**Our Ref: R/236/18/HH**  
**Your Ref:**

**Town & Country Planning Act 1990 (as amended)**  
**Town & country Planning (Development Management Procedure) (England) Order 2015**  
**Application for Planning Permission for Works or Extension to a Dwelling**

**Development**     Proposed car port, boundary wall to front and associated landscaping  
**Location**         57 North Lane Rustington

Proposed Car Port Design

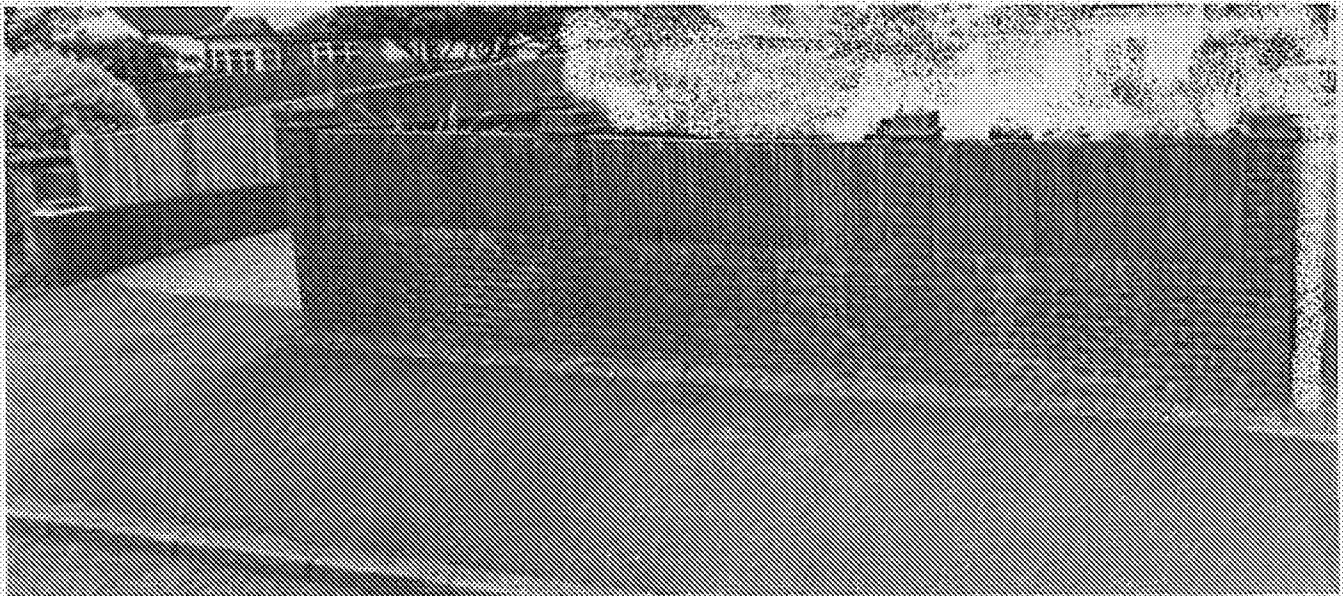
Please submit 1 electronic or 3 paper copies of the proposed other side elevation at a scale of 1:50 or 1:100. Please also note that elevations should be shown as 2D, please amend the elevation which has been shown as 3D. Further details can be found in the National Validation Requirements.

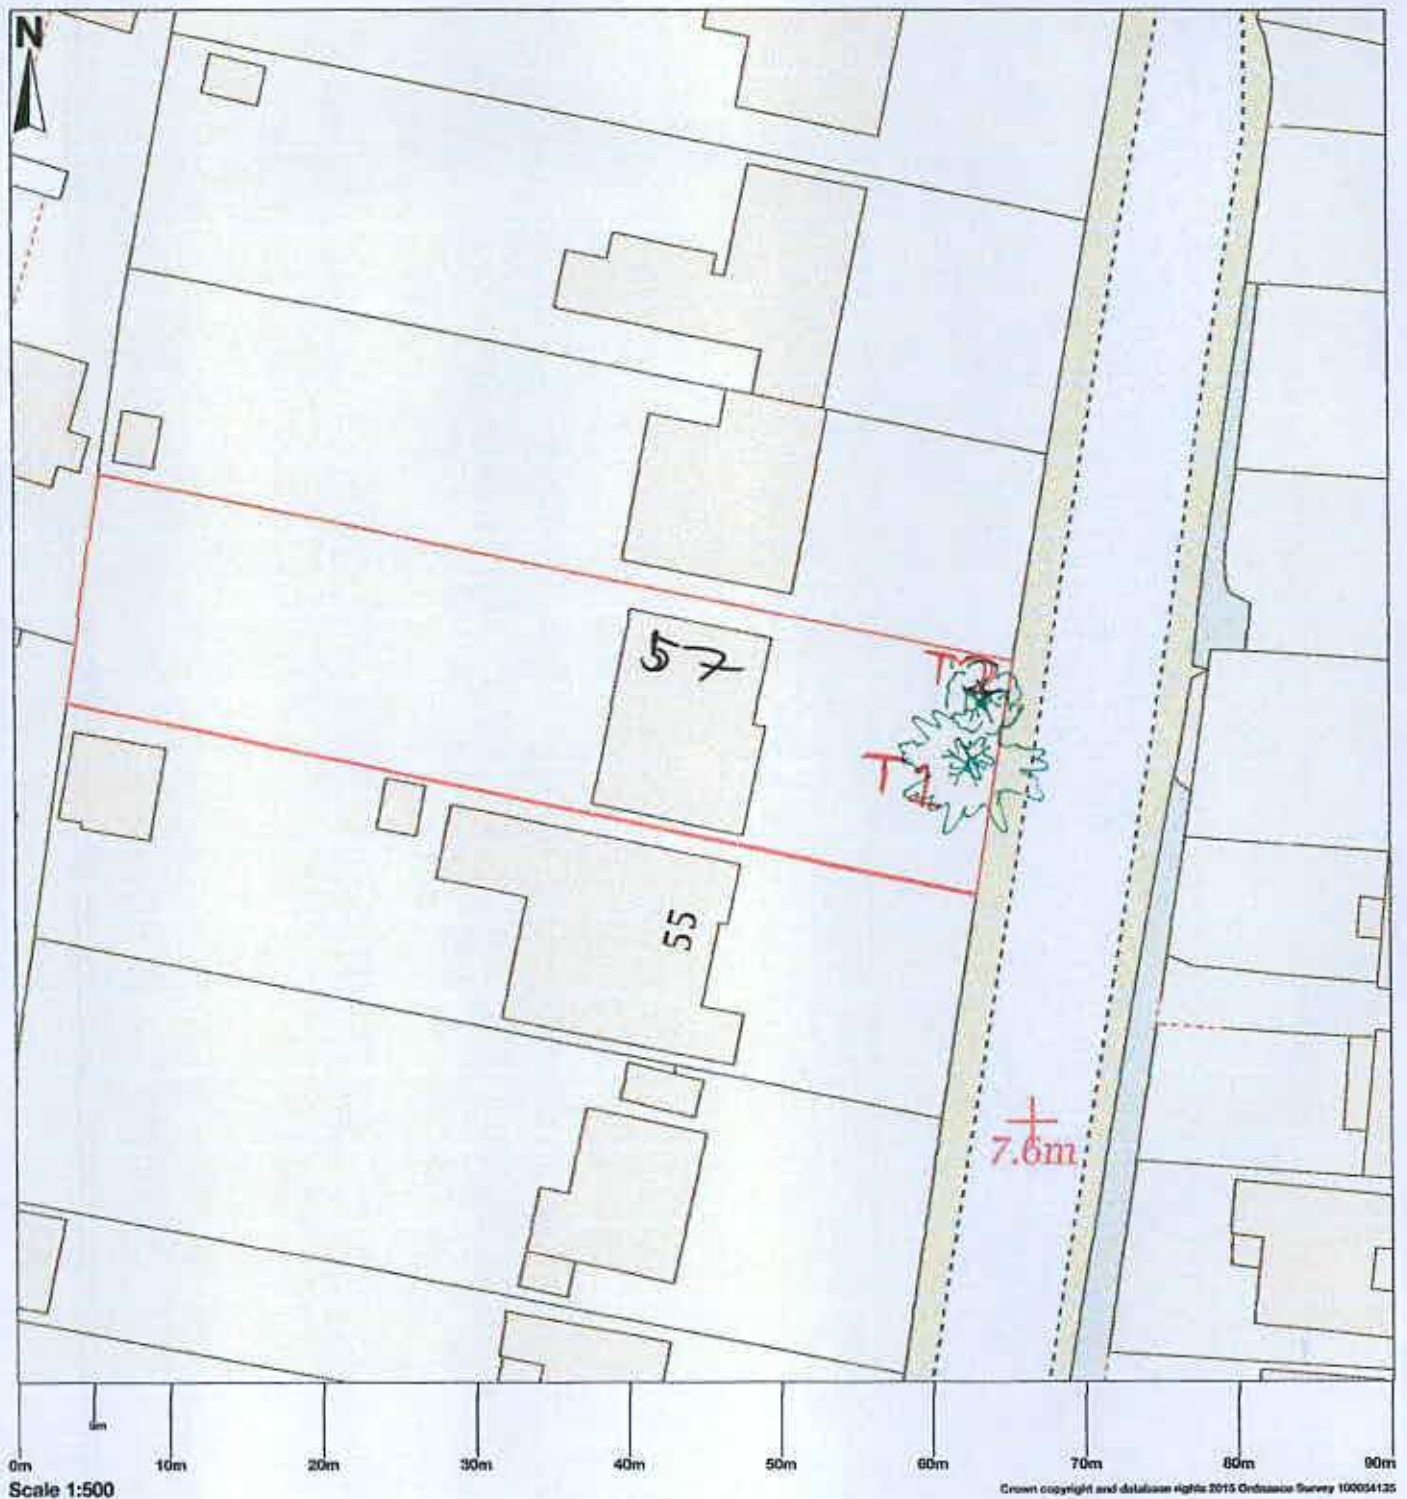
Please annotate the remaining dimension from the proposed car port to the boundary.

EAST Proposed 1:100

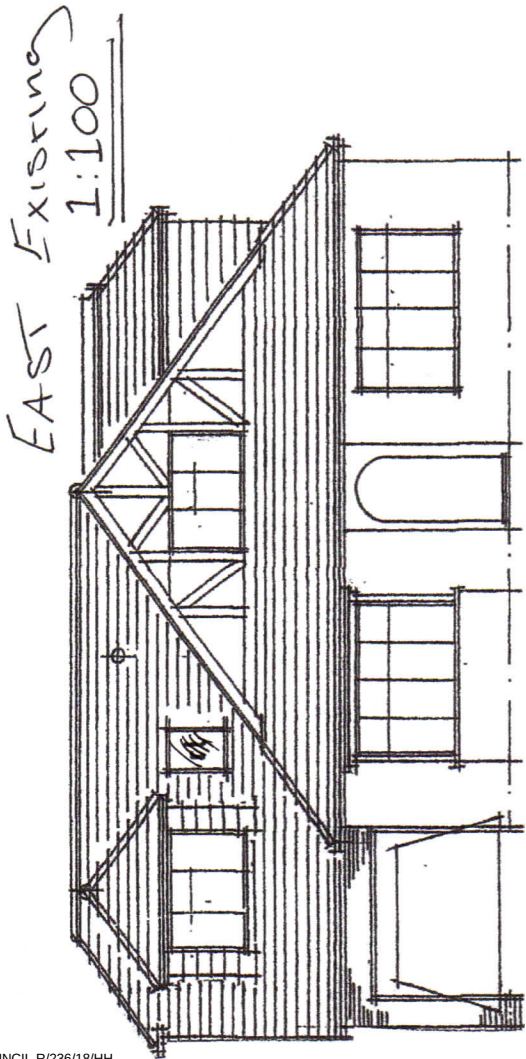
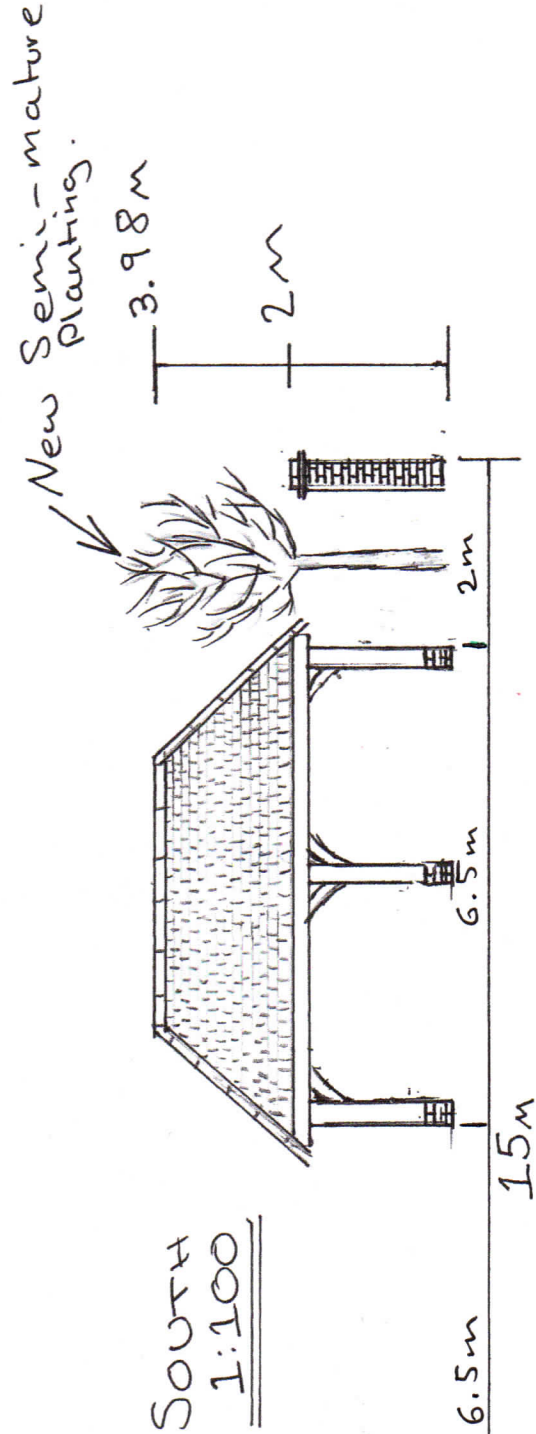
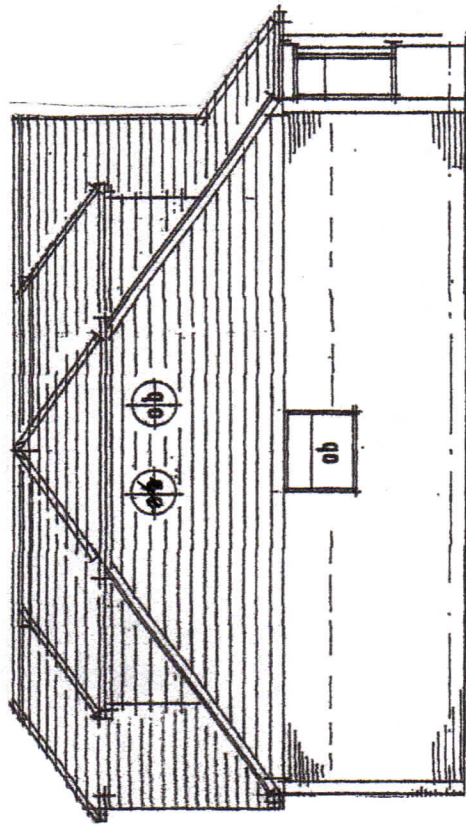
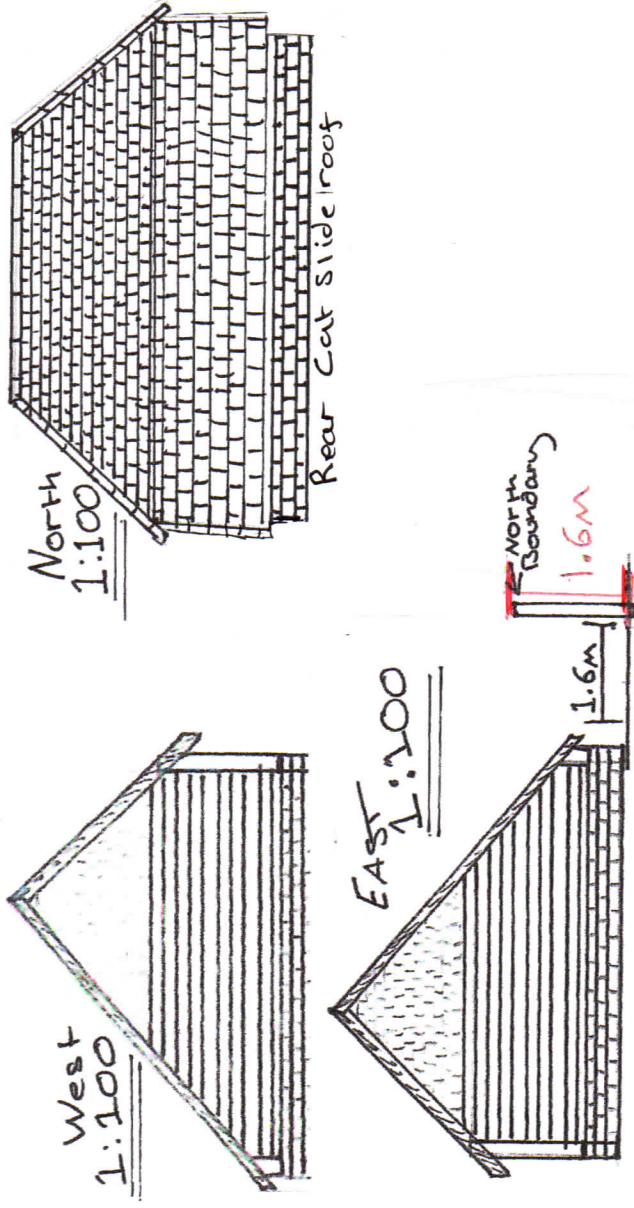
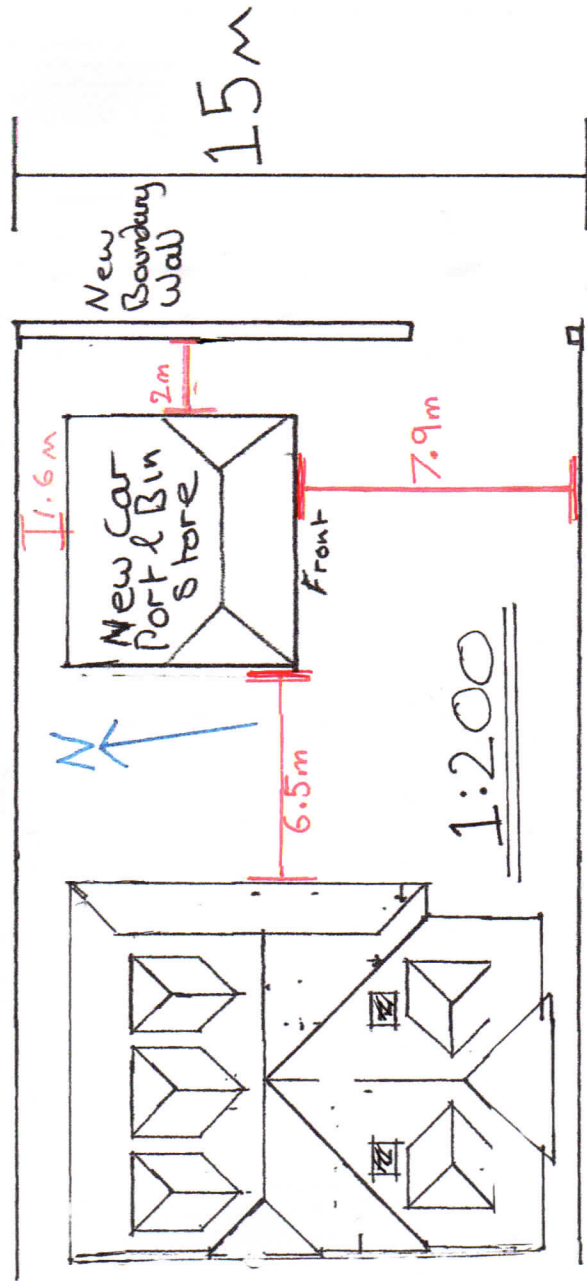
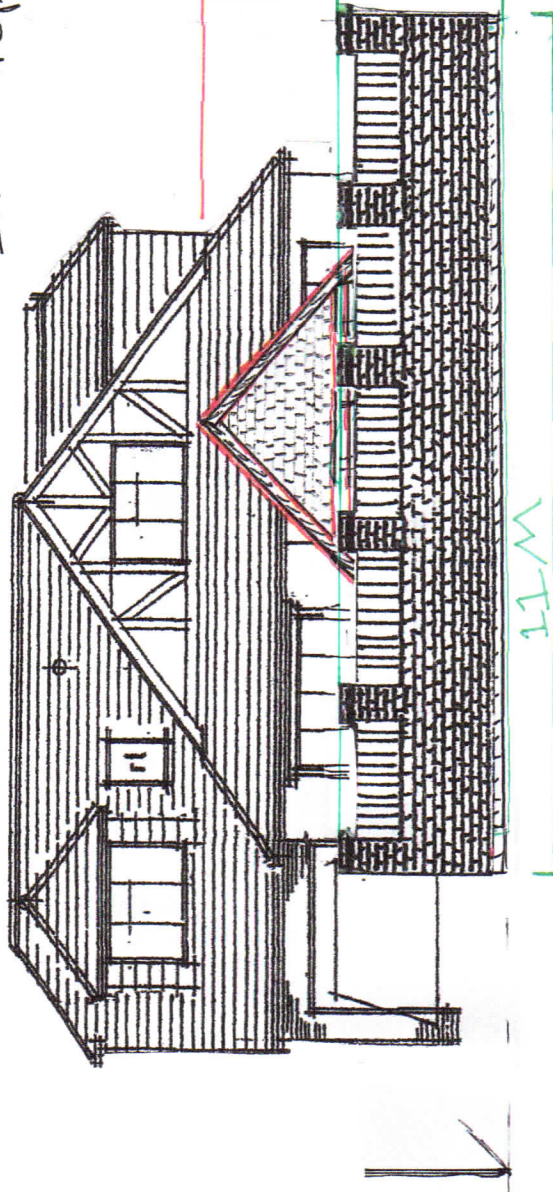
Some of the dimensions do not measure correctly: 2m on the proposed site plan, 11m on the proposed east elevation.
